**Subject: Independent Fire Protection Review for Cumberland County Civic Center Renovations**

A review has been completed of the fire protection construction documents (CD) set, dated 21 January, 2013, which has been developed to support renovation efforts at the Cumberland County Civic Center in Portland, ME. The documents reviewed included both the fire protection demolition and design drawings, along with the design specifications for the various fire protection and life safety related systems.

SHEET No. **LSB.30**

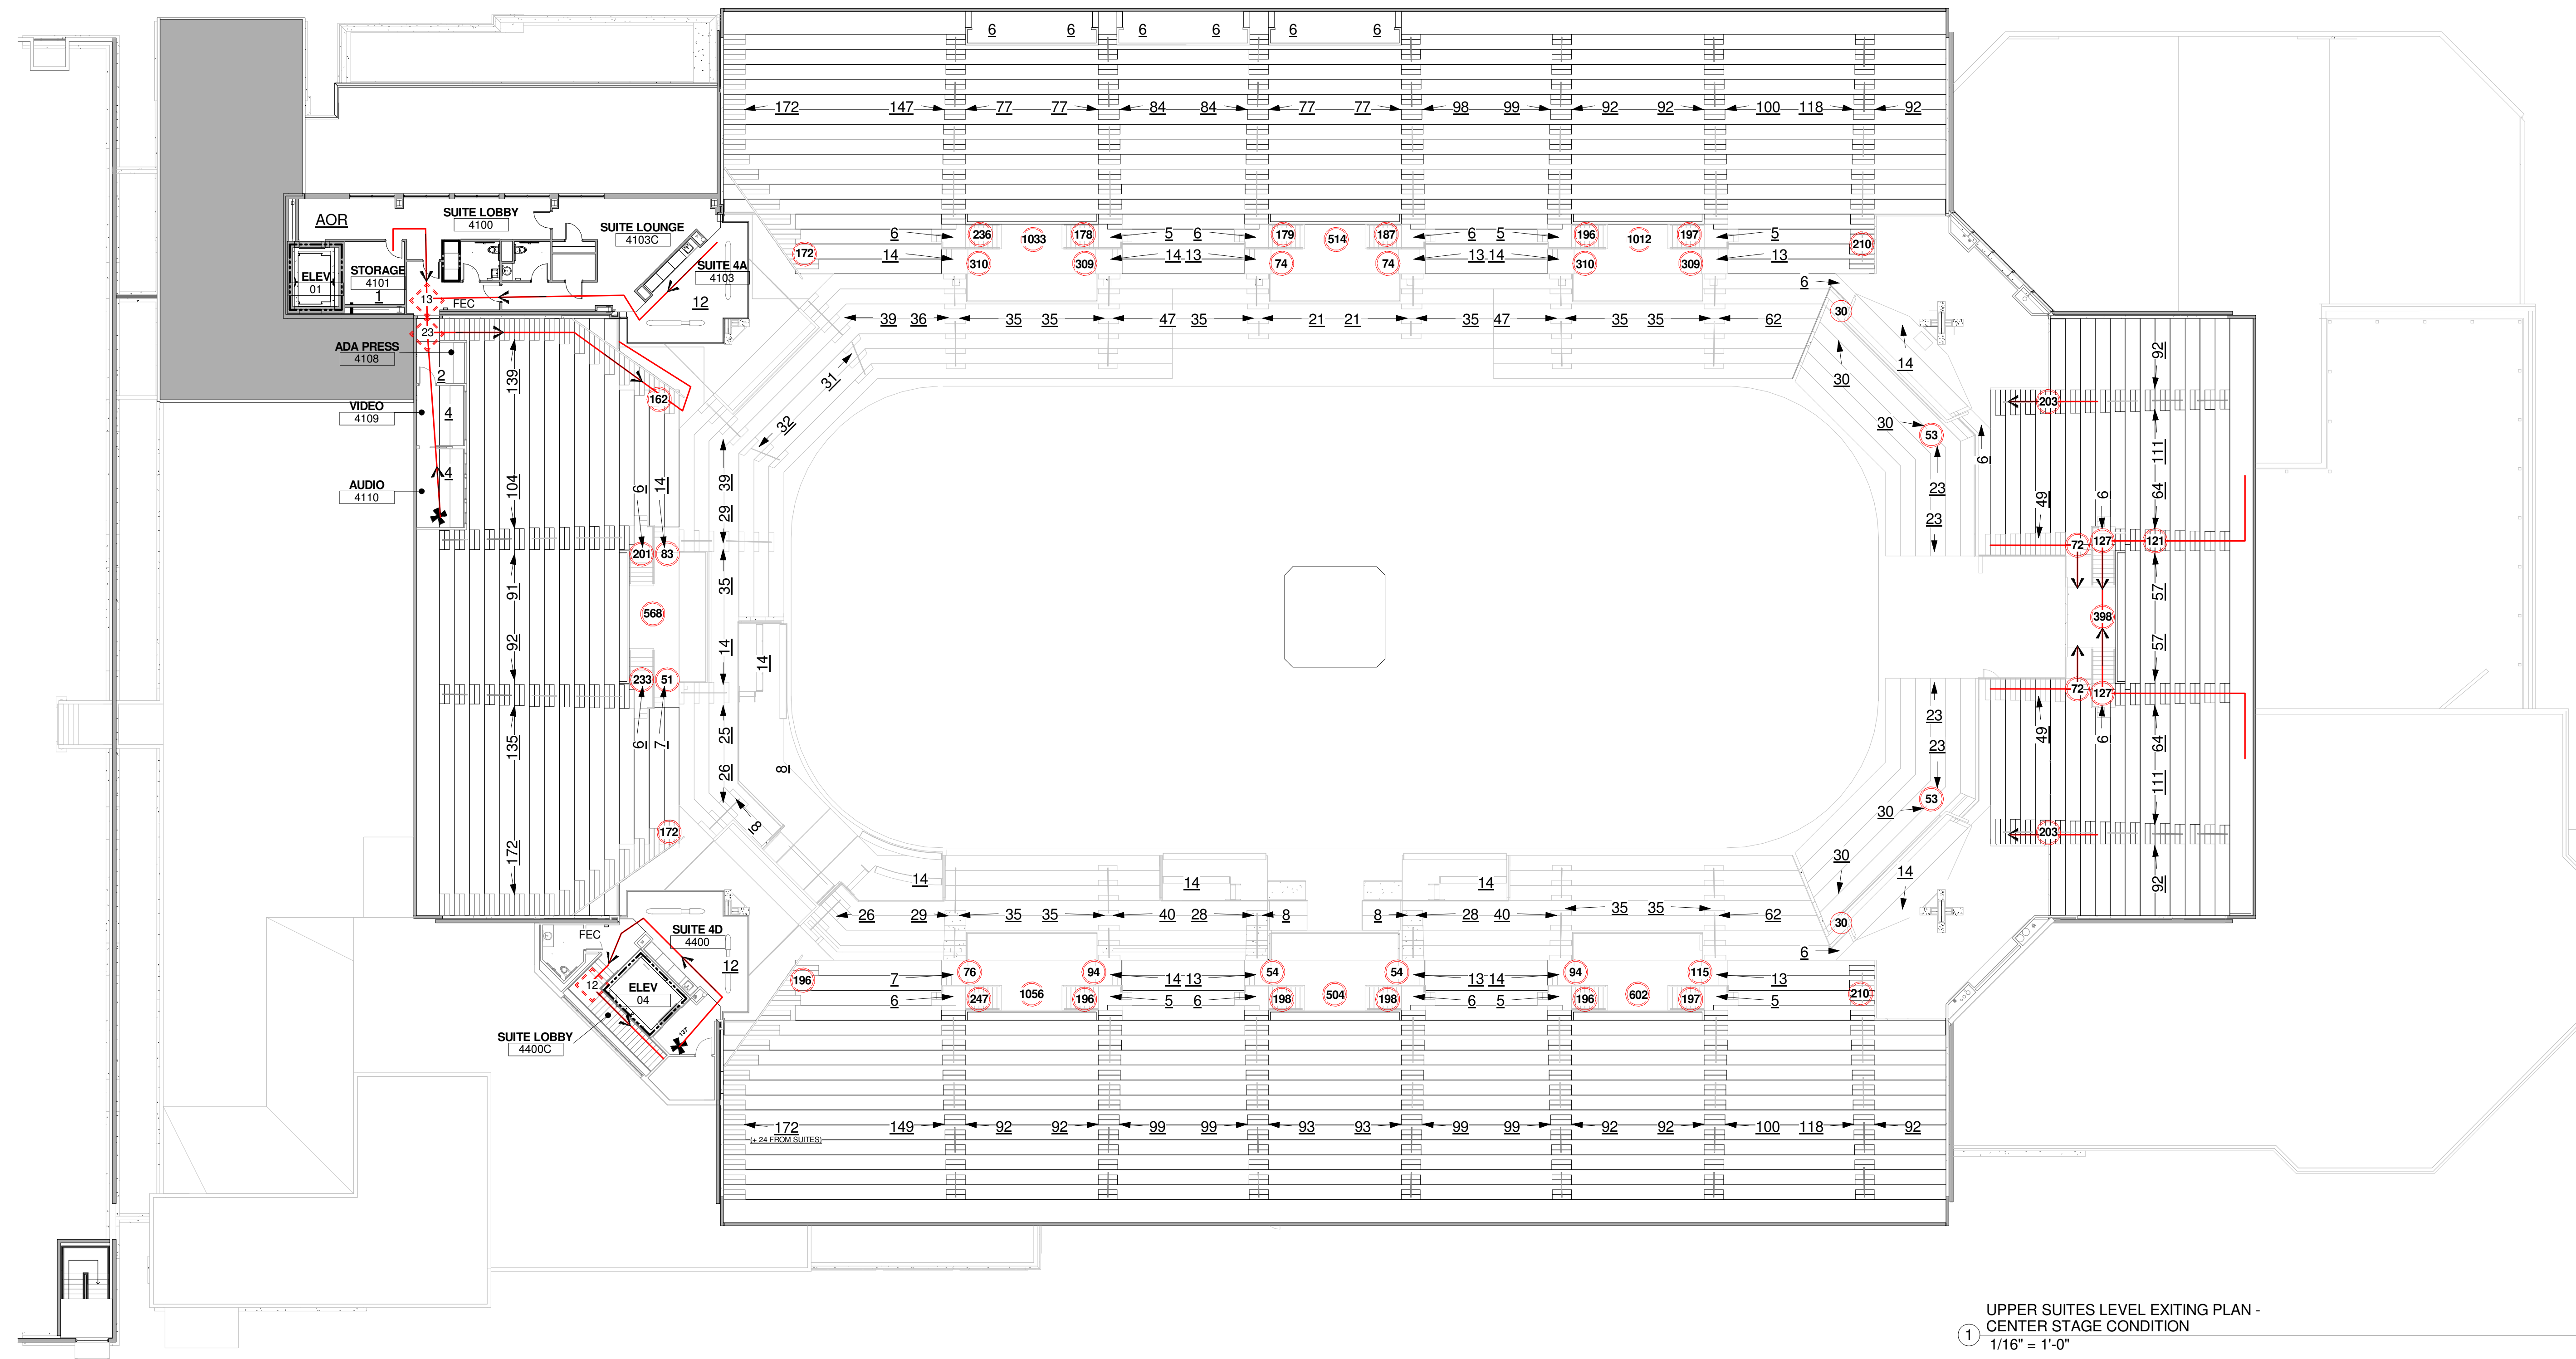
Some of the fire barrier requirements shown on the Life Safety Plans are not properly depicted and/or are not consistent with code requirements. For example, no fire rated barrier is depicted for the Fire Pump Room. These plans should be reviewed to verify that all fire rated barriers are properly depicted on the plans, to include highlighting requirements associated with floor/ceiling assemblies. It would also be recommended that all locations for the fire extinguishers be depicted on the life safety plans, such that they can be readily identified and verified as meeting code requirements.

WBRC CAD FILE: C:\Users\jaye.mahar\Documents\375700 - CCCC Electrical_jaye.mahar.rvt	
PROJECT No. 375700	GRAPHIC SCALE 1" = 10'
SCALE 1/8" = 1'-0"	
PROJECT MANAGER: JRB	SHEET No. FA.03
DRAWN BY: KRM	
CHECKED BY: S.JL

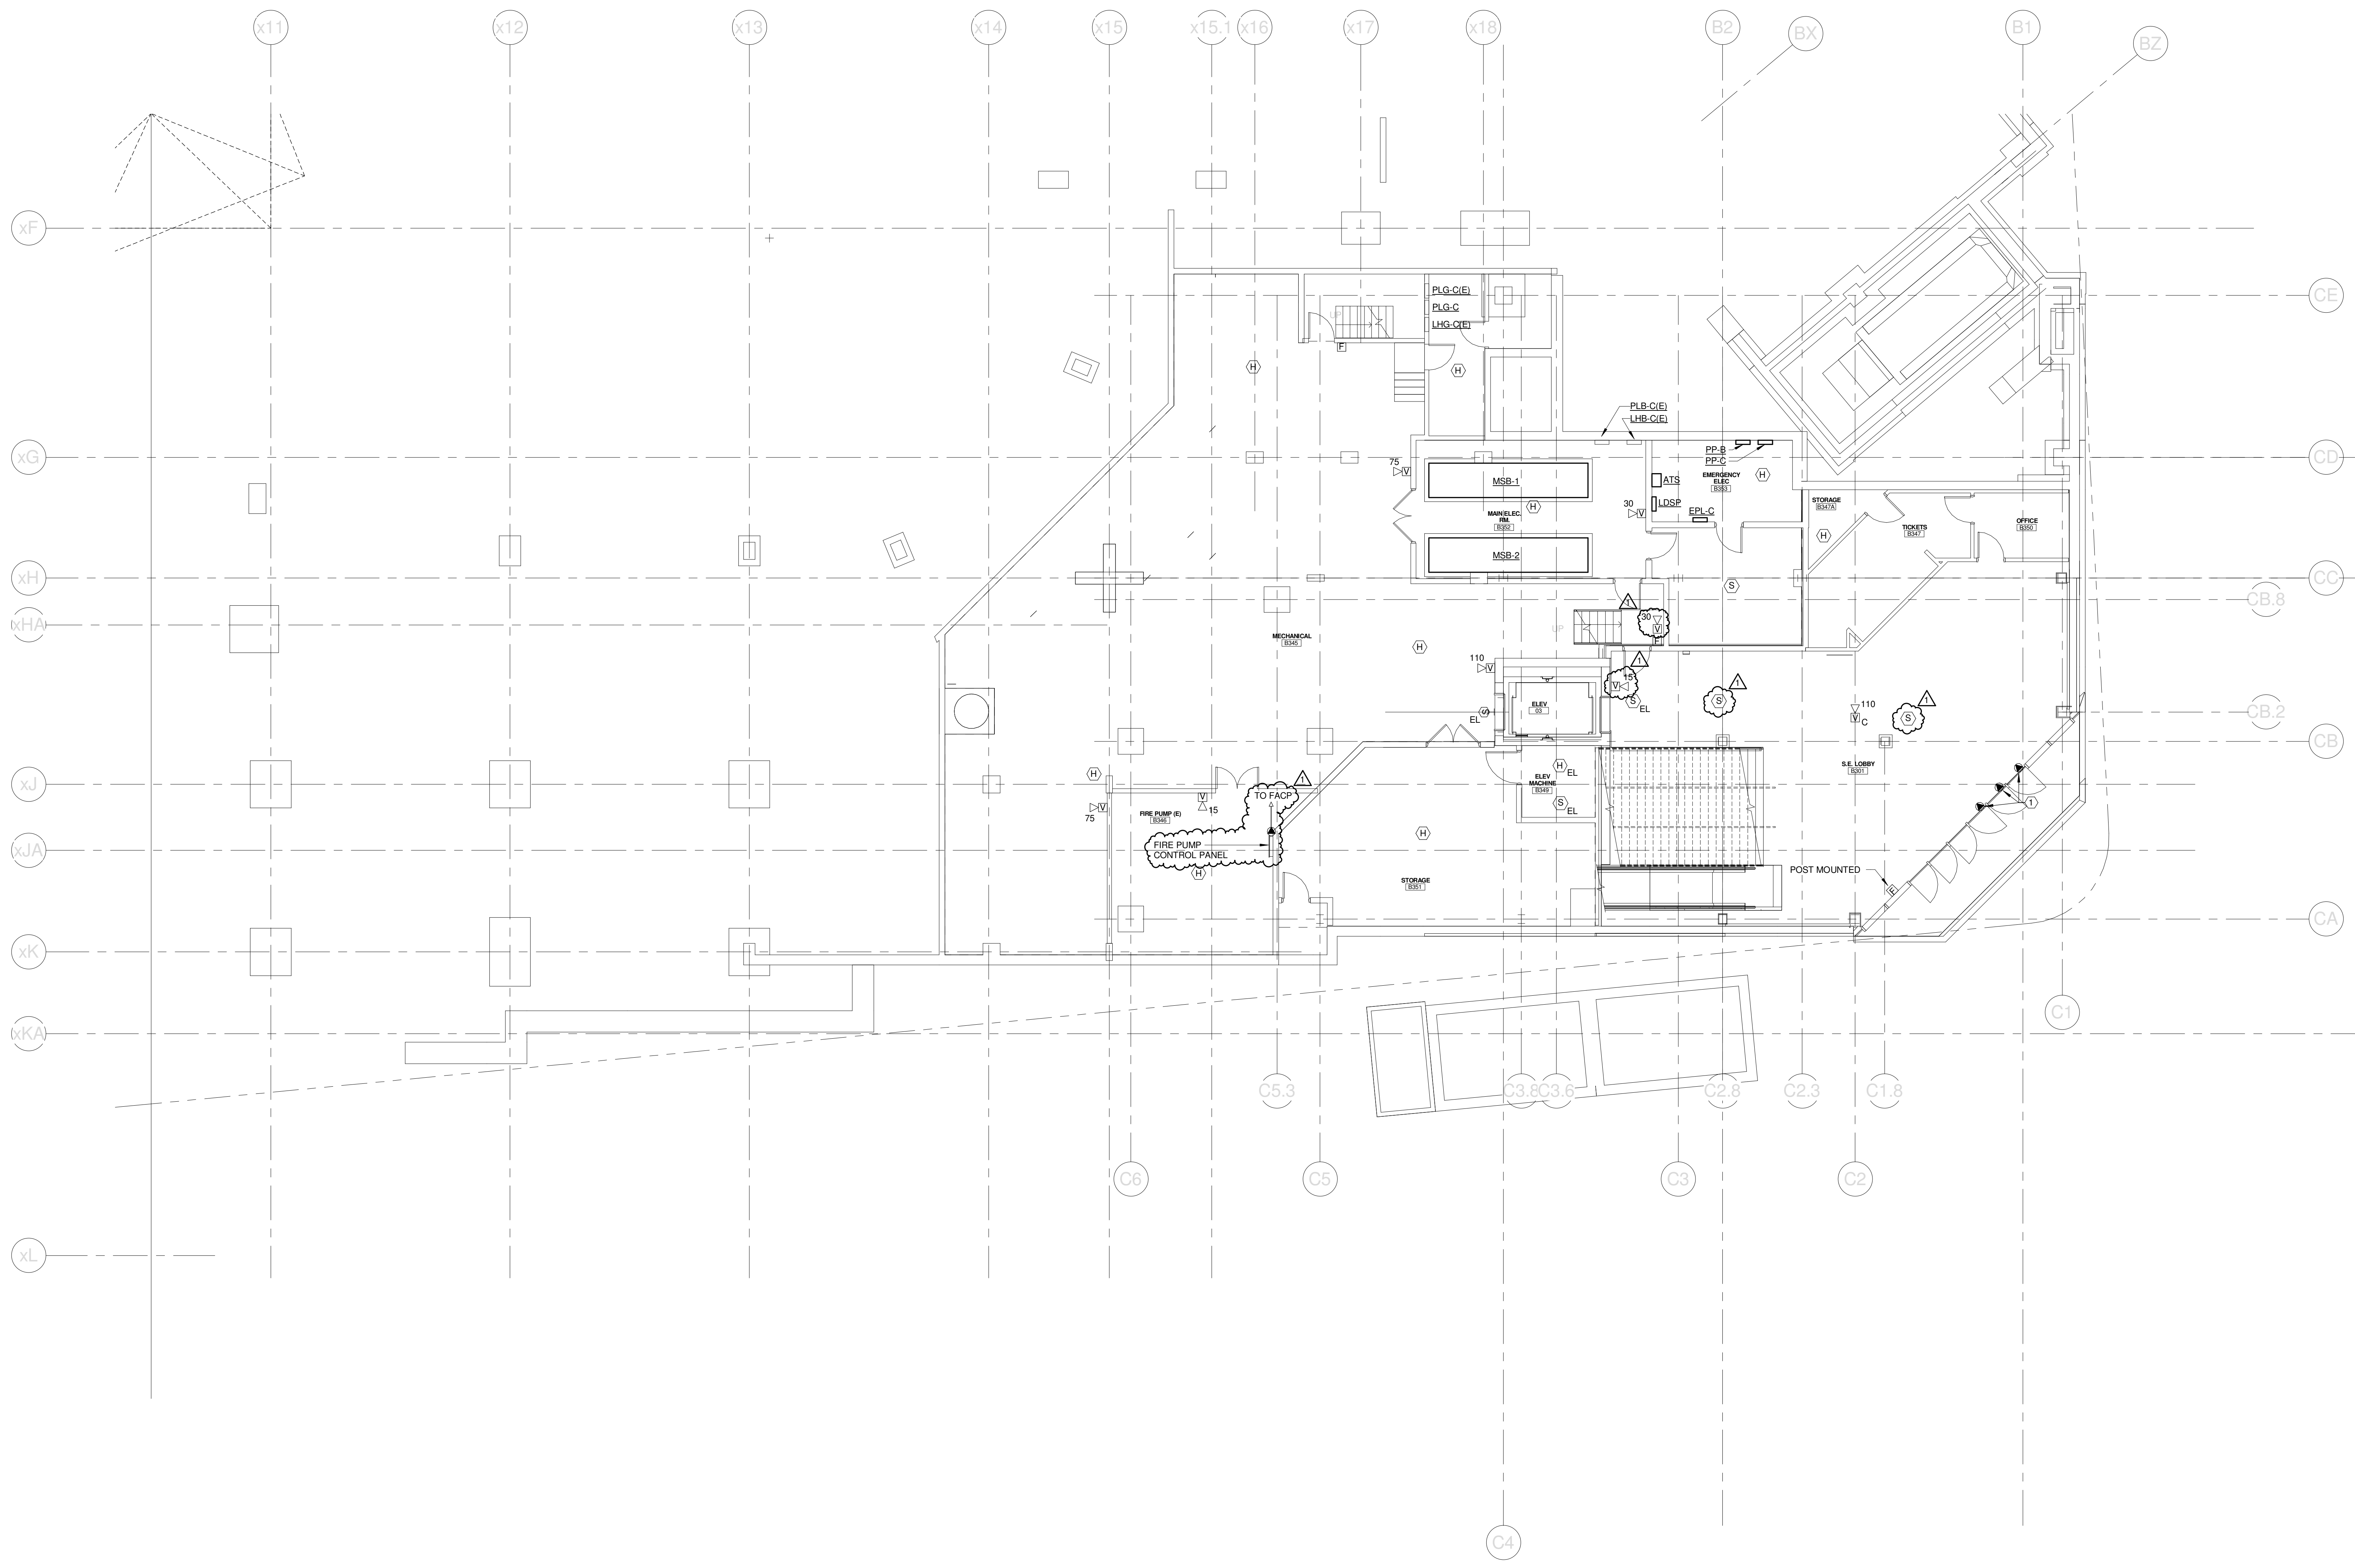
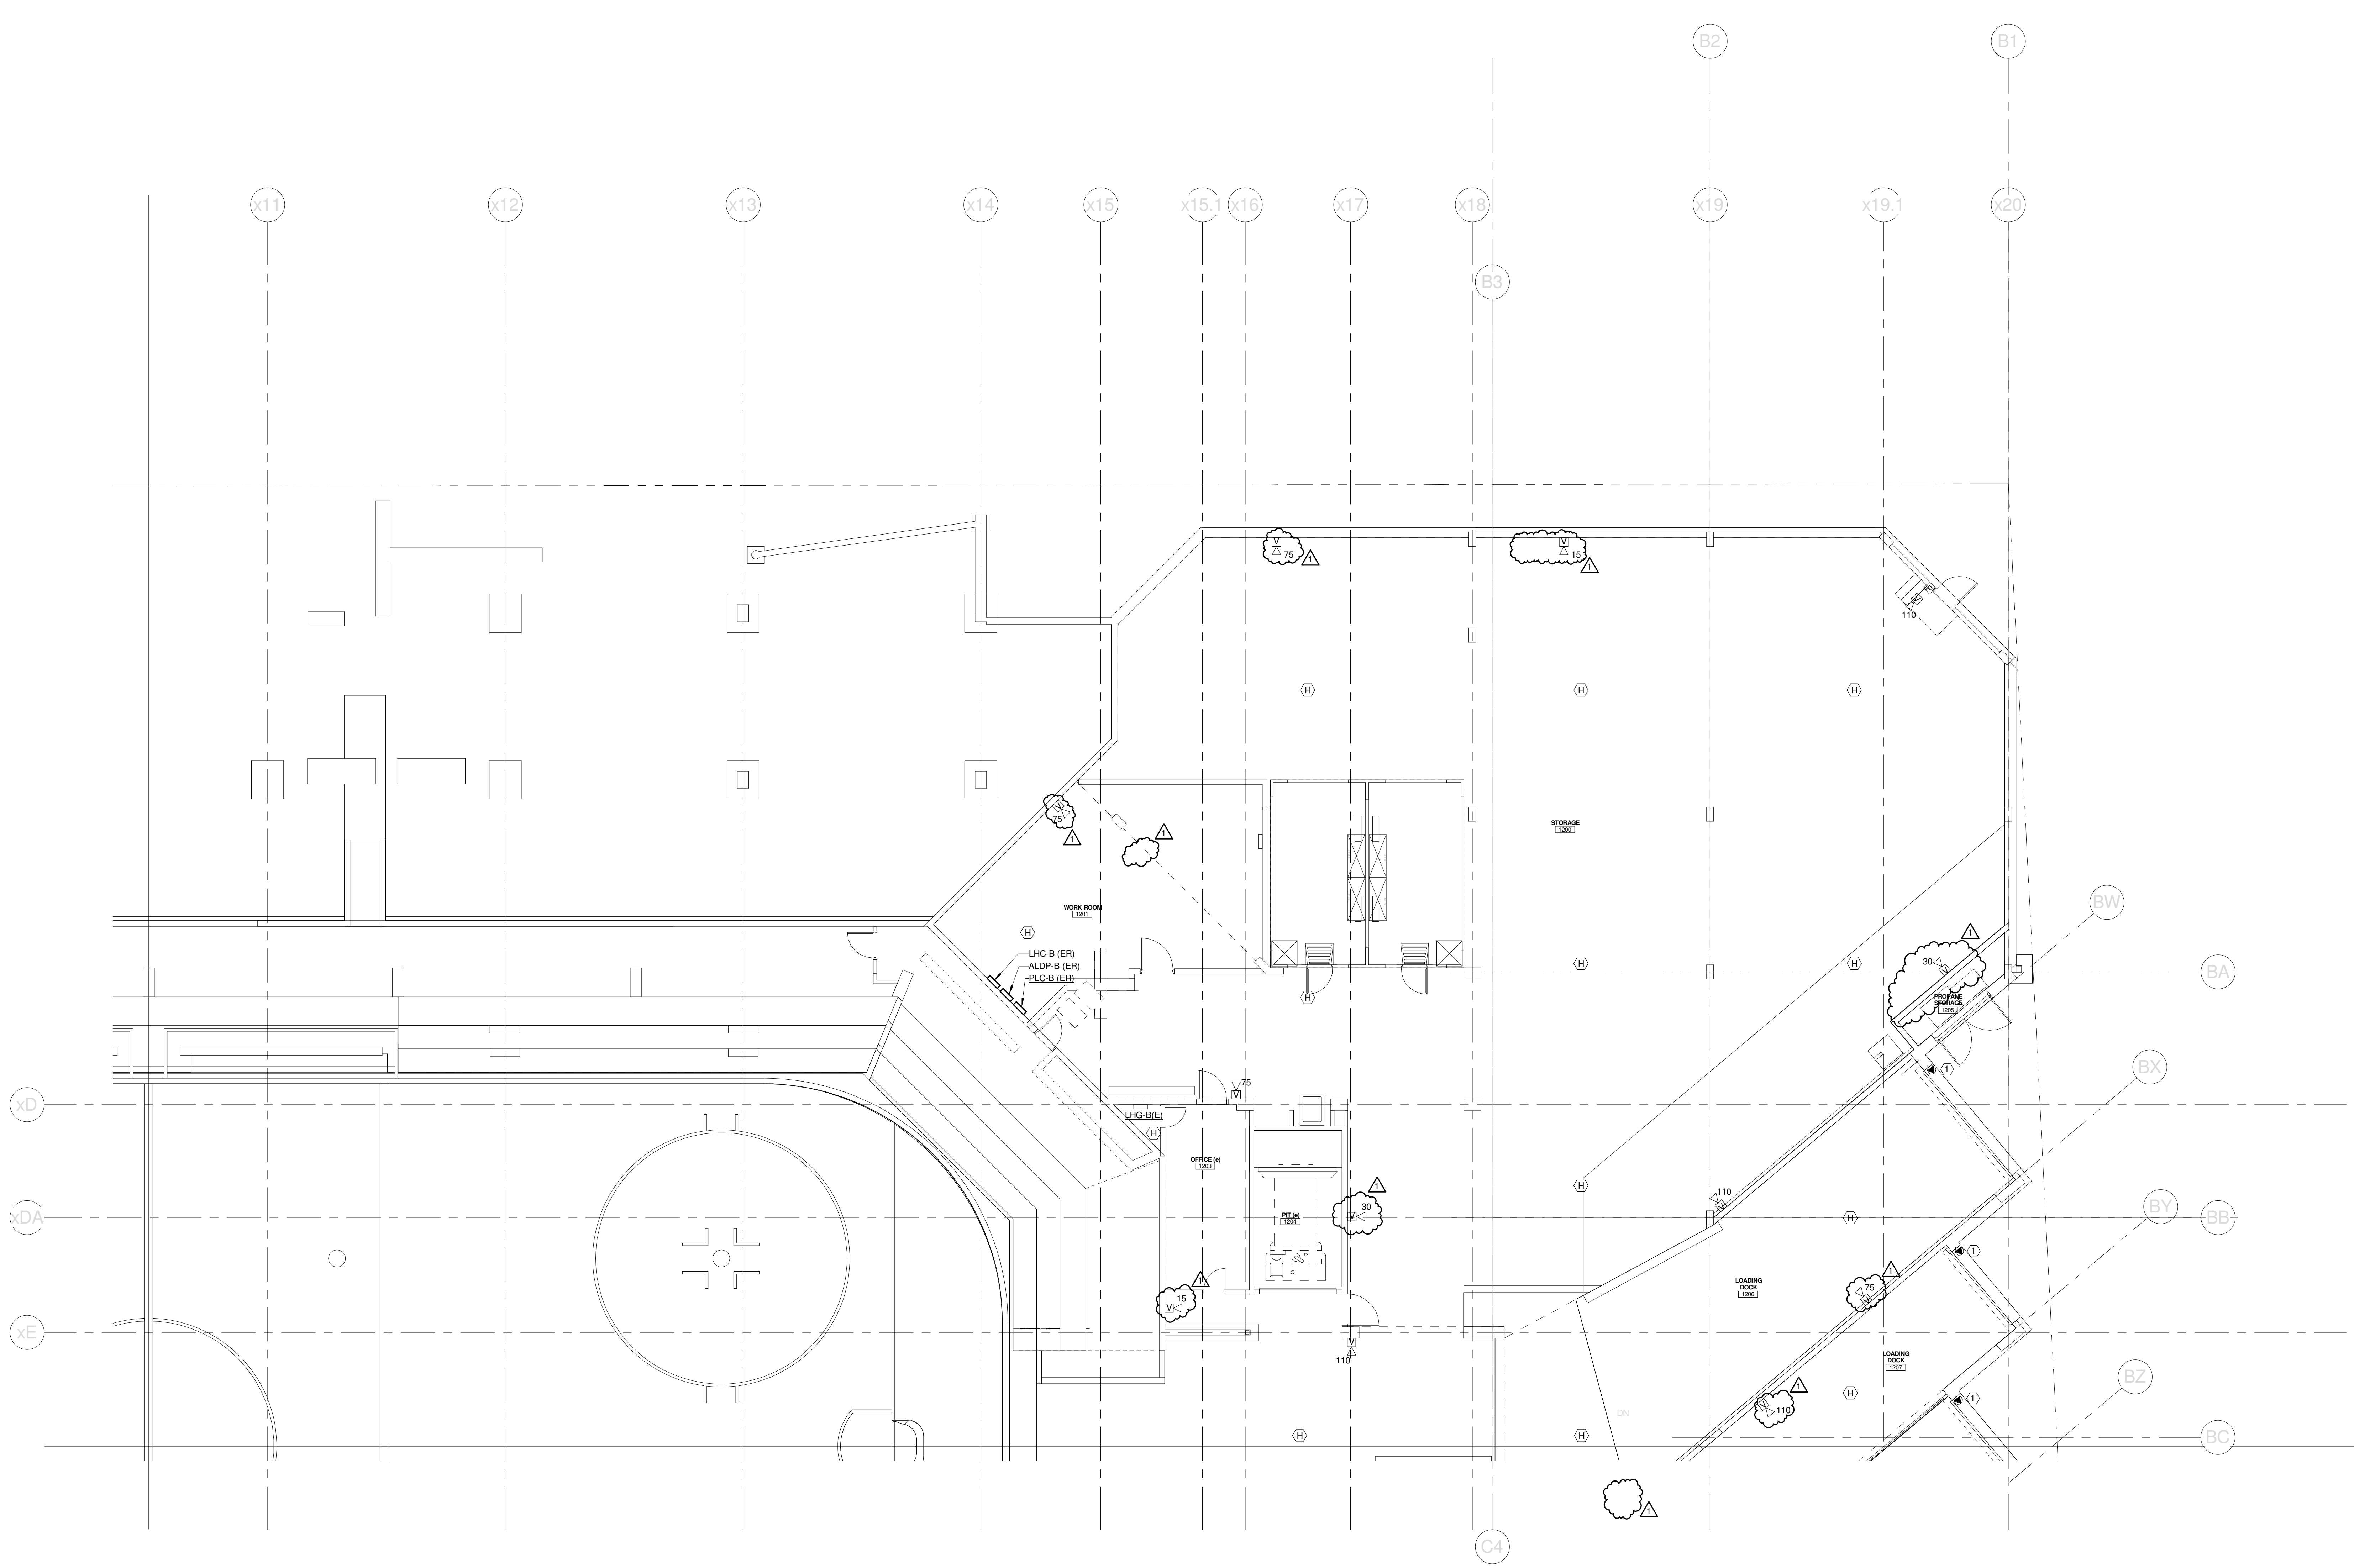
The fire alarm system components are being included with the electrical drawings. This makes a review of this system very difficult. The fire alarm system design should follow standard drawing standards and be depicted separately, using the standard drawing naming/numbering scheme (FA series). A review of the electrical drawings that depict the fire alarm system components indicates there are numerous problems, both from the lack of devices as well as devices being depicted in areas where they are unnecessary. For example, numerous smoke and heat detectors are shown in areas where they are not needed, such as in corridors and closets. Additionally, symbols are used on the drawings that are not depicted in the legend. The fire alarm system design drawings must be reviewed in detail to not only ensure that they provide a code-compliant system, but one that does not require numerous components where they are not needed or required.
